**ADC Planning Consultation
Response from the Historic Buildings Adviser**

Application Number	A/104/17/L
Address	6 Longback Cottages, Arundel Road, Angmering BN16 4JT
Description	Application for Listed Building Consent for side extension including internal adaptations and replacement of 3 existing windows like for like.
Case Officer	Anita Gardner
Site Visit

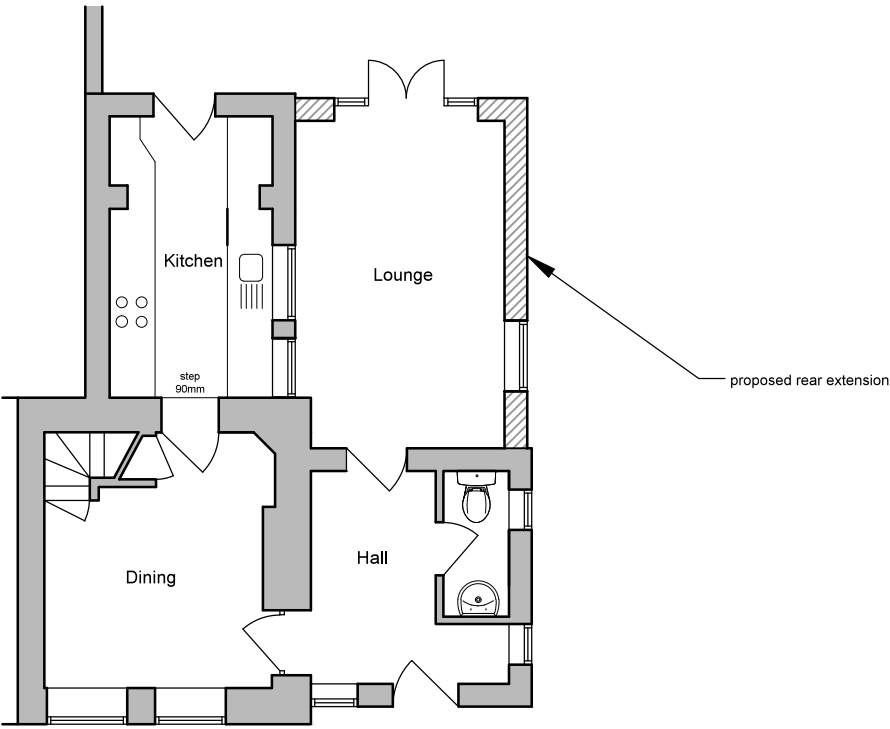
Whilst the proposed extension has been reduced, the addition is still of a scale and massing that is likely to impact the appreciation of the cottage and the terrace more generally. The ridge height is only slightly lower than the host building whilst the footprint of the new development exceeds that of the primary accommodation.
